Application for a Non-Material Amendment Following a Grant of Planning Permission

Erection of a single storey rear and side extension with roof lights to the dining and living room

23/01148/FULH

DRAWING TITLE:
PROPOSED
GROUND FLOOR PLAN
SCALE @ A3: 1:100
REV:
P03

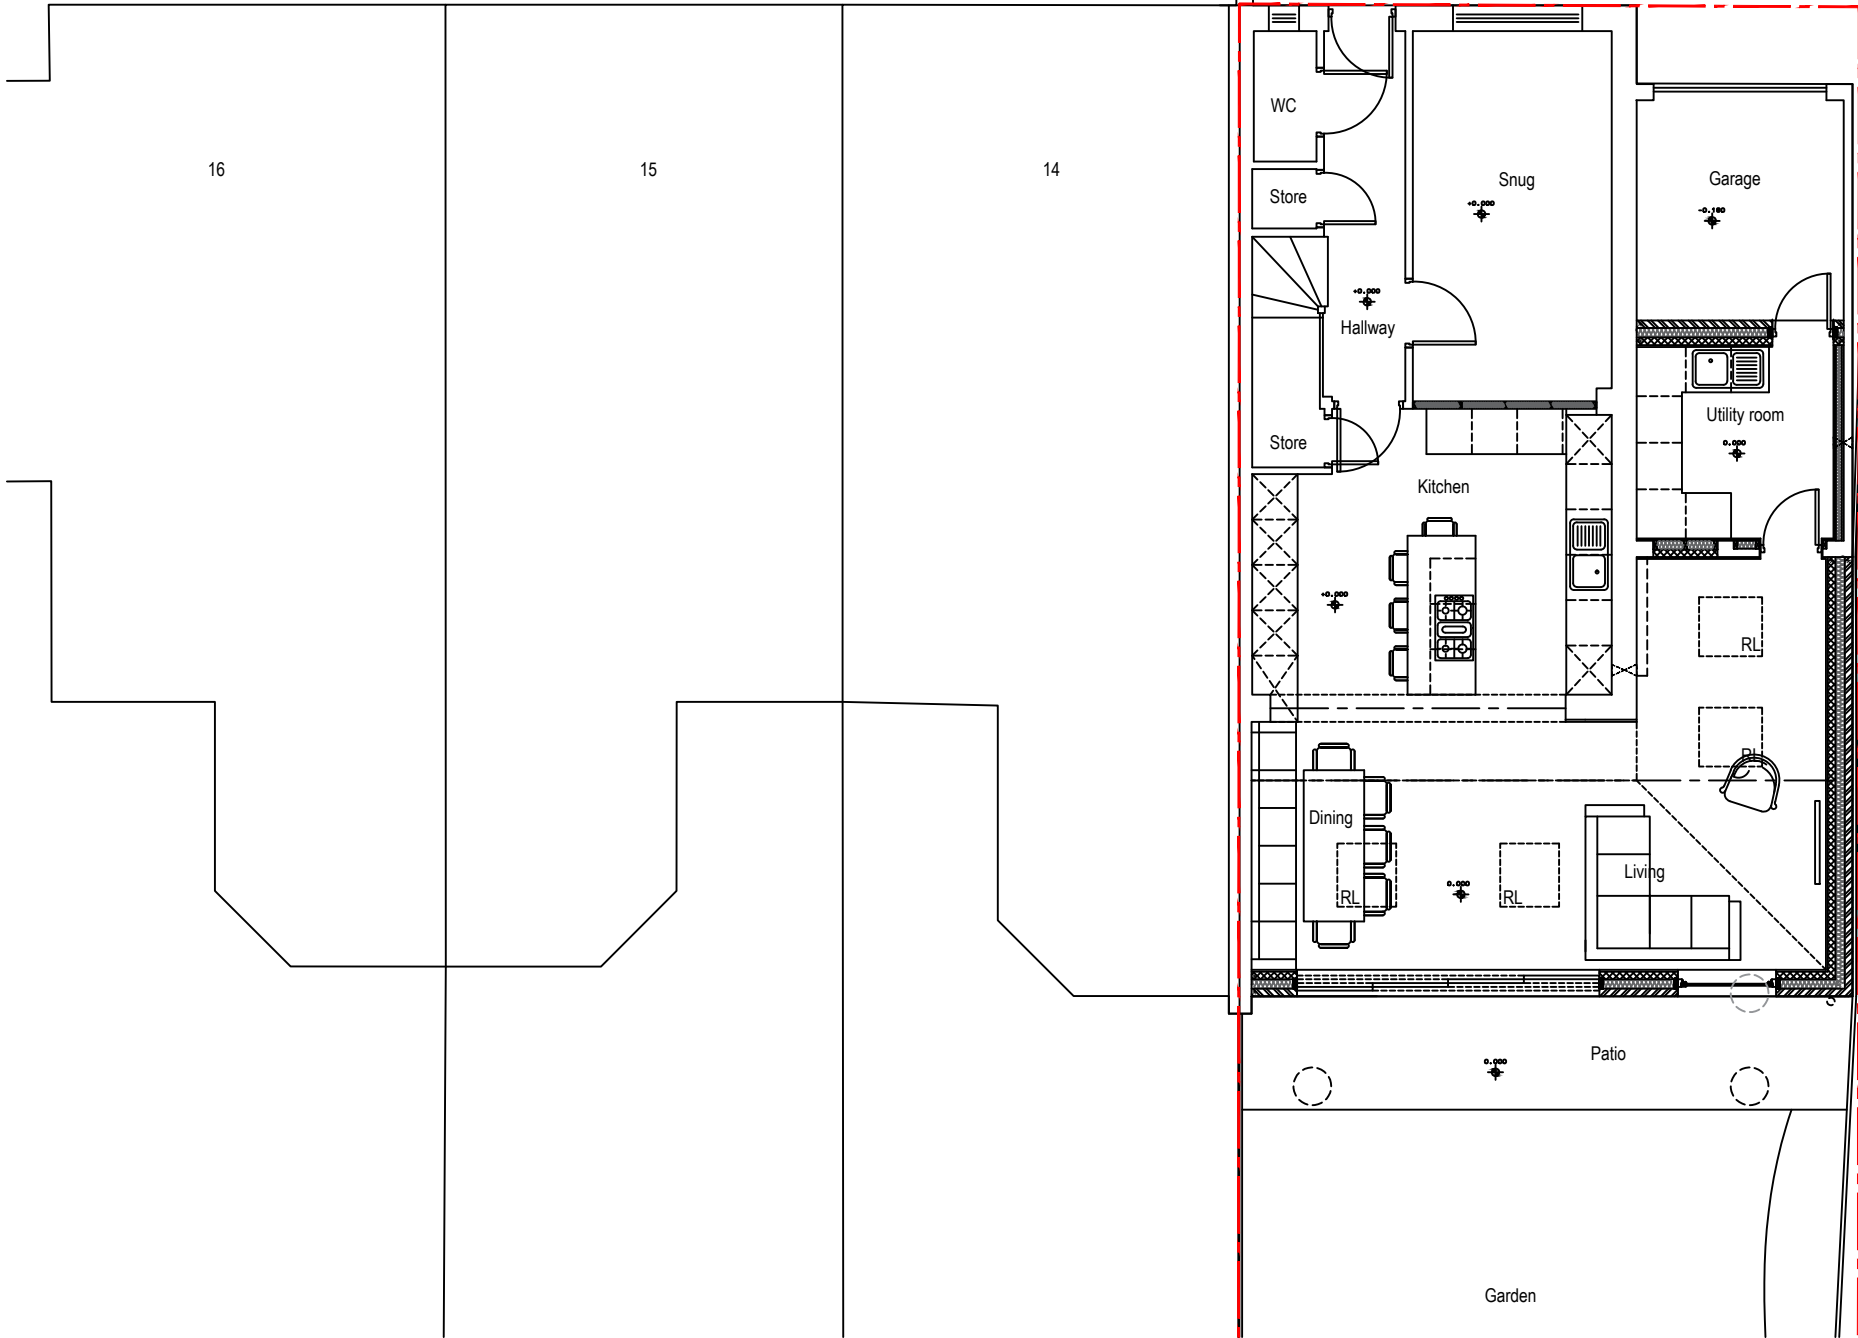
Extending the bi-fold door from 3.2m to 4m.

To allow more light in to the kitchen and dining room.
